Subject: Revision of proposed modification (MOD 9) to Shoalhaven Starches Pty Ltd  
Project Approval MP06\_0228

Reference: Proposed Modification dated March 2016 (Cowman Stoddart Pty Ltd)  
Draft approval MP 06\_0228 MOD 9- Packing Plant  
Harwood Acoustics Night Time Operations Assessment 4 Nov 2016

In response to the draft approval MP 06\_0228 MOD 9 – Packing Plant, Shoalhaven Starches Pty Ltd propose the following changes to the Operating Conditions:

Noise Barrier Walls

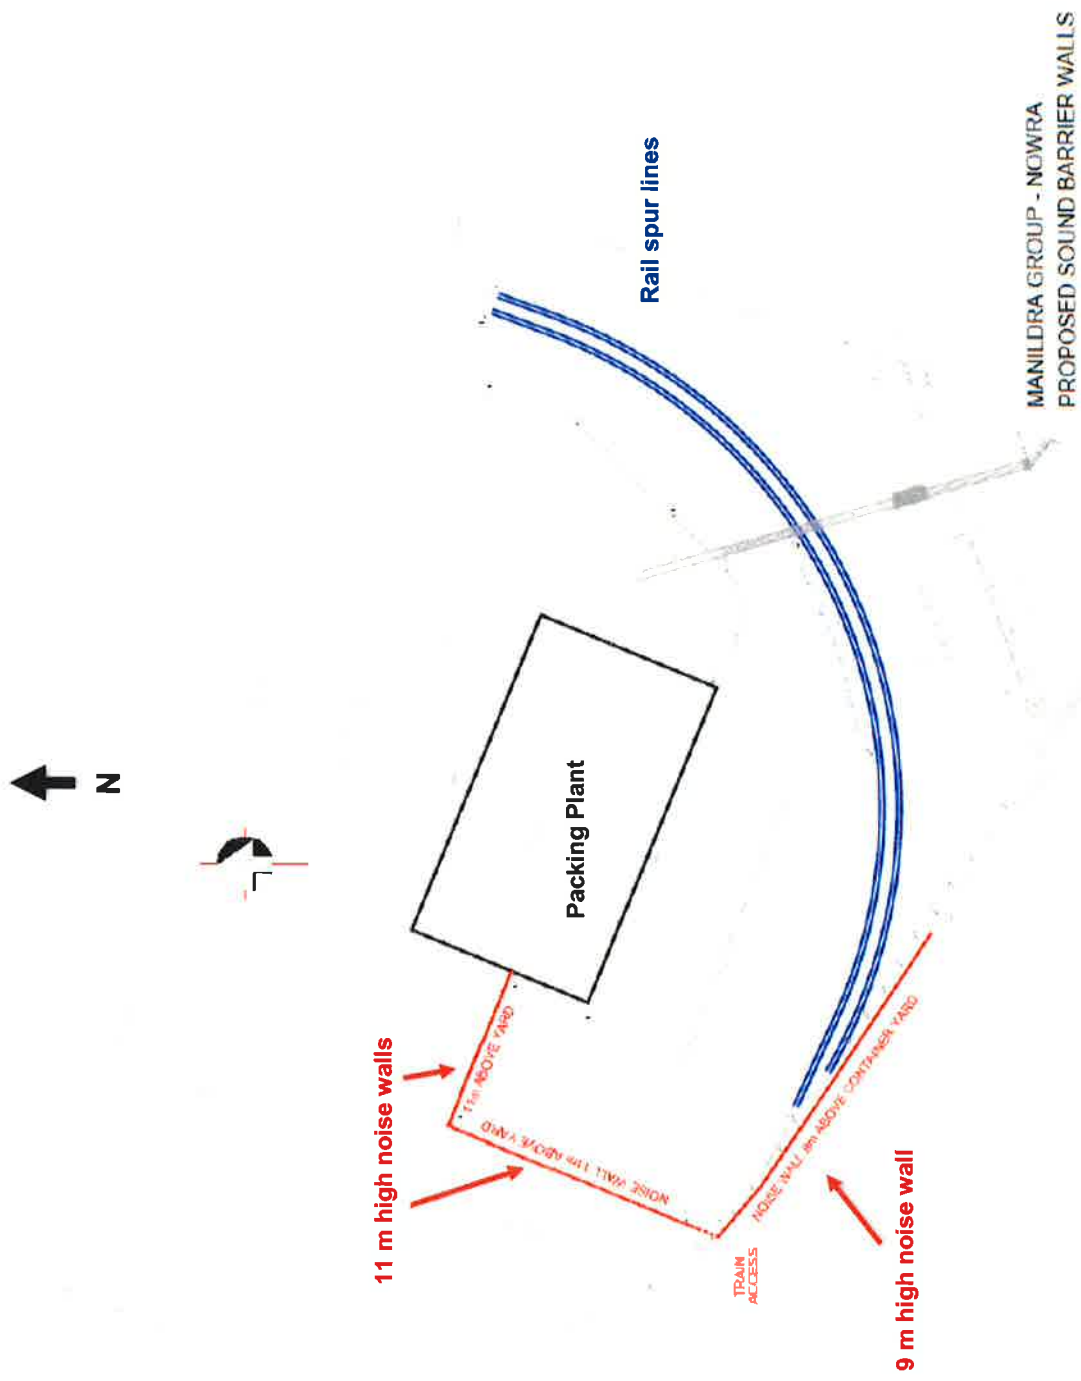
Shoalhaven Starches preferred solution to mitigate the train and loading / unloading noise is to increase the noise barrier wall height and move the south western wall to the outside of the master siding thus placing the spur line as far as necessary entirely inside the noise protected container yard.

With the railway network limitations to consider and an available solution that meets requirements, Shoalhaven Starches Pty Ltd here request revision of the consent to allow train movements on the spur lines at all hours plus loading and unloading at all hours.

Shoalhaven Starches preferred solution is to put into place a completely effective noise barrier enabling three high stacking of containers to occur anywhere in the container yard and at all hours.

Shoalhaven Starches Pty Ltd here requests revision of the consent to allow handling and stacking of all containers to maximum three containers high at any location within the container yard at all hours.
